Observation to An Coimisiún Pleanála on application

PAX07.323699 proposed wind farm at the townlands of BEAGH, BEAGHMORE, CLOONBAR, CLOONMWEELAUN, CLOONAGHLASHA, CLOONTEEN, CORITLAUN, DERRYMORE, IRONPOOL, SHANCLOON, TOBEROE, TONACOOLEEN, CO GALWAY.

To erect 11 turbines with a tip height of up to 179 metres

**PEER REVIEW OF APPROPRIATE ASSESSMENT SCREENING AND NATURA
IMPACT ASSESSMENT WITH REGARD TO APPLICATION FOR PLANNING
PERMISSION BY RWE RENEWABLES LTD FOR "SHANCLOON
WINDFARM" (PAX07.323699)**

Figure 1: Special Protection Areas (SPAs) within the vicinity of the proposed development, showing hydrological connectivity to Lough Corrib SPA

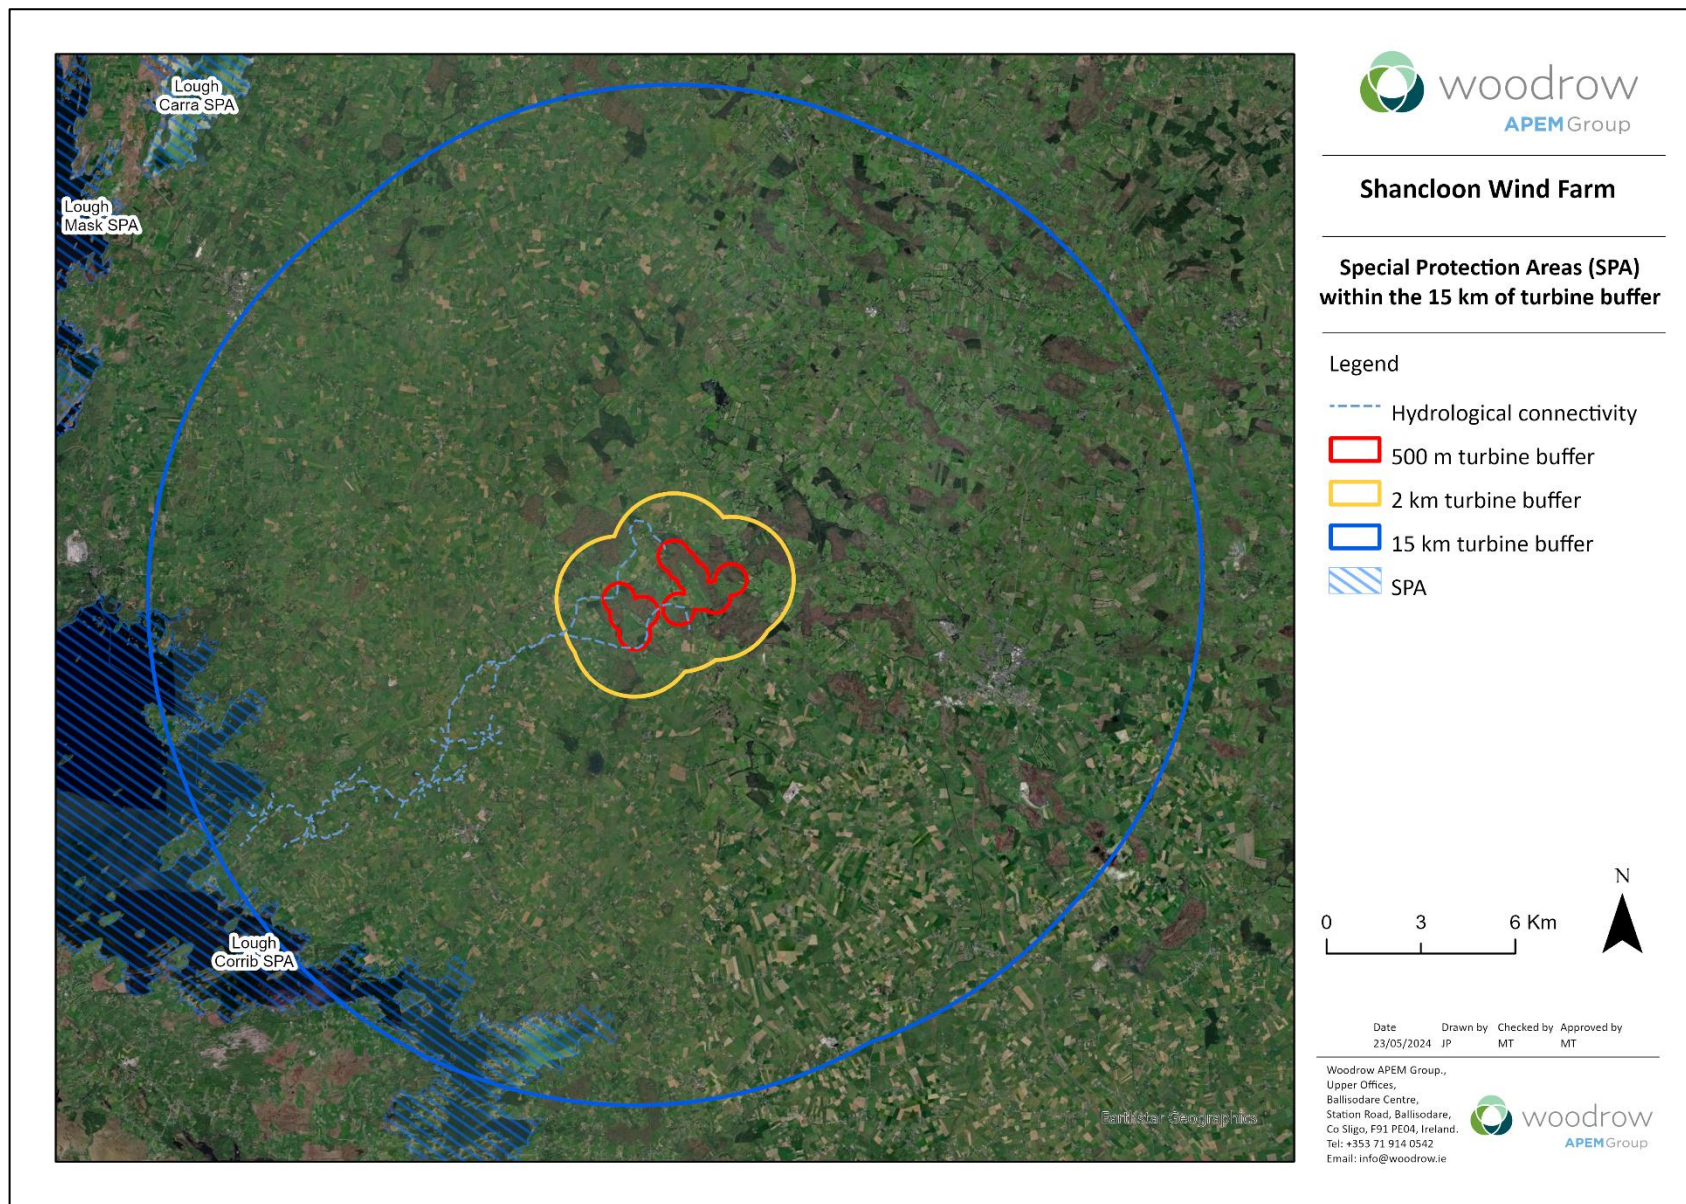
the methodology fails to take into account the presence of turloughs (a priority habitat) in the same buffer. No fewer than five SACs, designated for Turloughs occur within less than half this buffer distance. Within the Natura 2000 data form associated with these sites, the importance of the sites for birds is highlighted. Indeed, the Natura 2000 data form for Greaghan’s Turlough indicates the importance of the site for Whooper Swan, noting that with regard to Quality and Importance

Research at the University of Galway^{3, 4} has documented that there are at minimum 16, 29 and 114 turloughs within 5km, 10km and 15km respectively, of the centre of the proposed wind farm development. The ecological connectivity between these turloughs and Lough Mask SPA/Lough Corrib

SPA was not assessed within the appropriate assessment process, even for those sites designated as Natura 2000 sites. Although these sites may be designated on the basis of the presence of given habitats, the importance of these features to avifauna (both breeding and over-wintering) is recognised within the Natura 2000 data forms for the sites. Turloughs as an ecological feature are virtually unique to Ireland and in particular the west of Ireland, providing invaluable foraging and roosting habitat for wintering birds in particular. The SNH Guidelines do not take into account the importance of these ephemeral habitats, which vary from season to season and year to year with regard to ornithological interest. The failure of the Appropriate Assessment screening process to take into account potential significant likely impacts on key (avifaunal) components of the ecosystems for which these sites are designated must be considered a fatal flaw in the process. The complex interactions from season to season and year to year between birds using these turloughs and adjacent SPAs was not assessed, and at minimum five Natura 2000 sites (Arkill Turlough SAC, Greaghan's Turlough SAC, Kilglassan/Cahevavostia Turlough Complex SAC, Shrule Turlough SAC and Skealaghan Turlough SAC) have not been taken into account in the Appropriate Assessment screening process. Indeed, only Shrule Turlough is mentioned within the text of the Appropriate Assessment screening and Natura Impact Statement, and only to indicate that it is not hydrologically connected to the proposed development.

The failure of the Appropriate Assessment screening process to adequately identify an appropriate zone of influence has had the impact of ignoring a number of pertinent sites (albeit SACs, of ornithological importance) that almost certainly host significant numbers of Qualifying interests of SPAs proximate to the proposed development.
